1 Joy Place - Preliminary Traffic Comments

Hi Jean – The following summarizes my preliminary traffic comments following a review of the application materials.

BRICK DRIVEWAY APRON

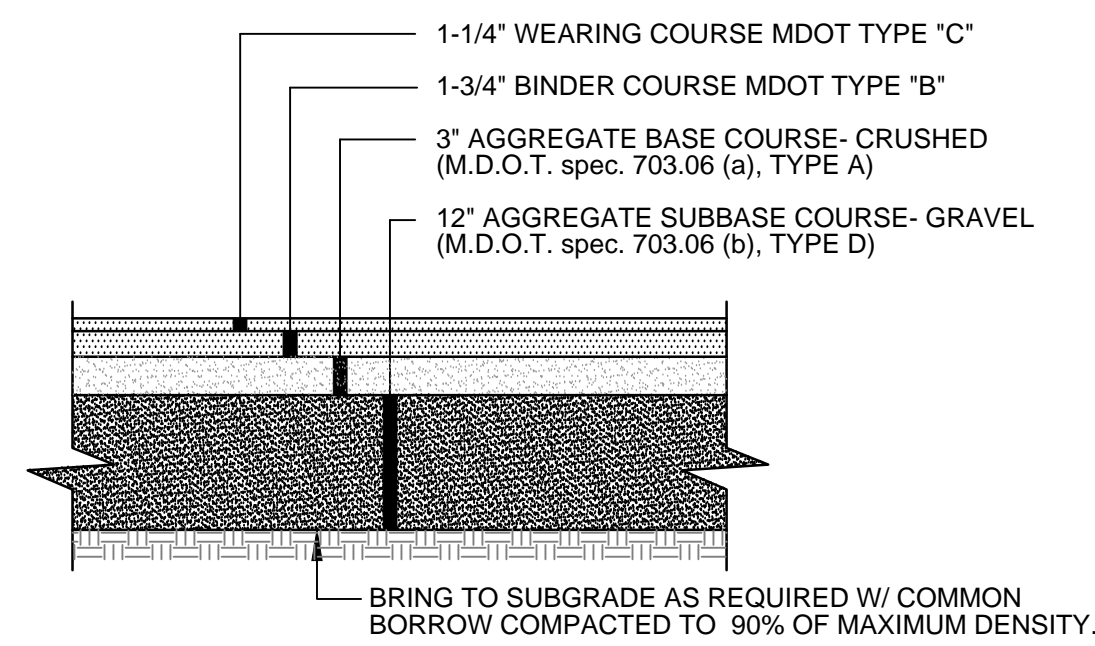
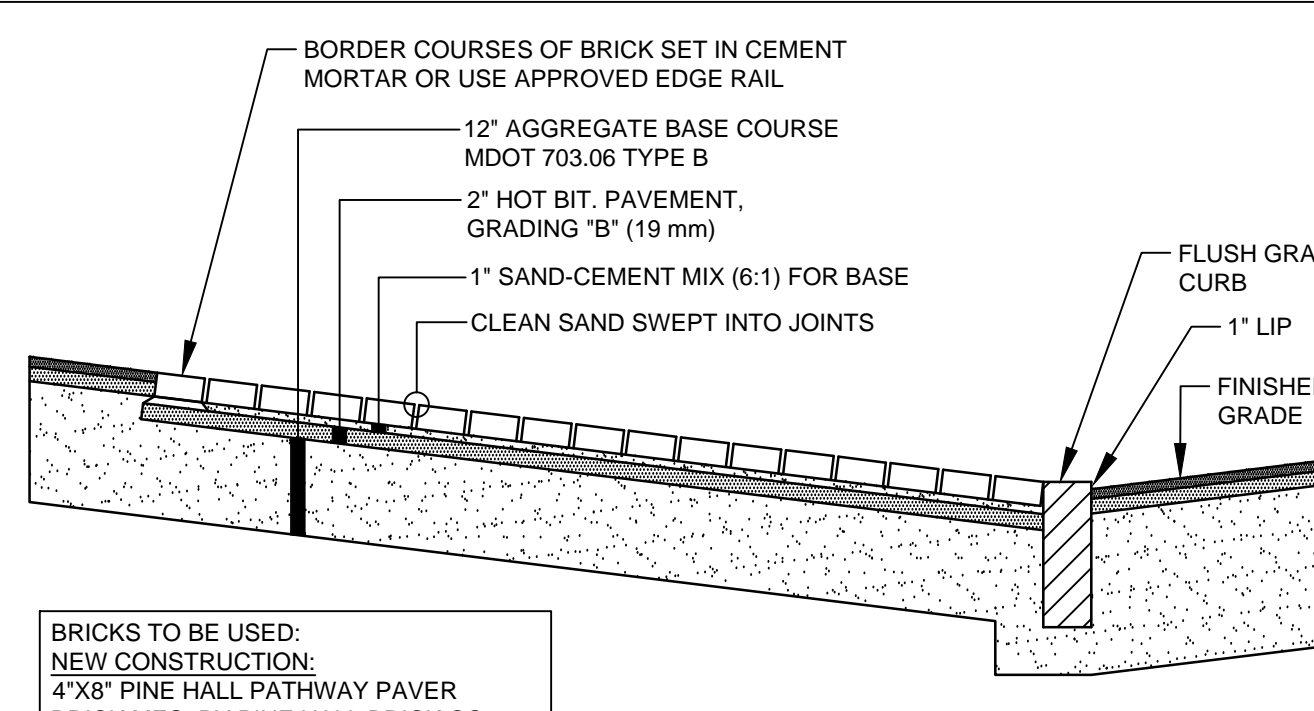
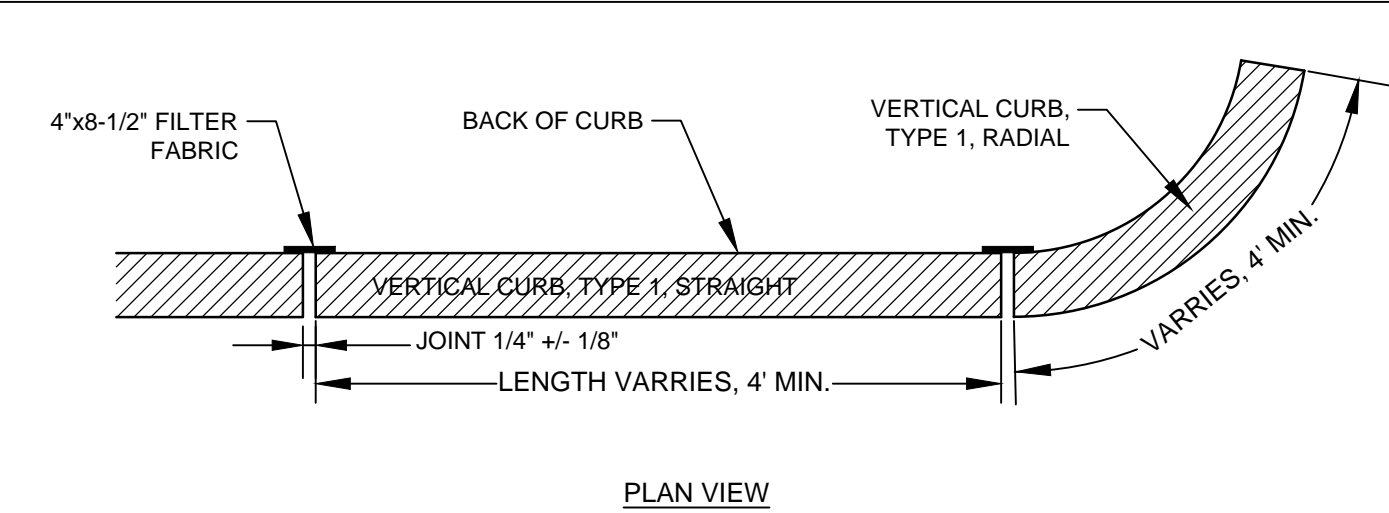
- The applicant should note how the tandem parking spaces will be managed.
- The driveway apron shall be designed to provide a maximum cross-slope of 2 percent along the pedestrian accessibility route.
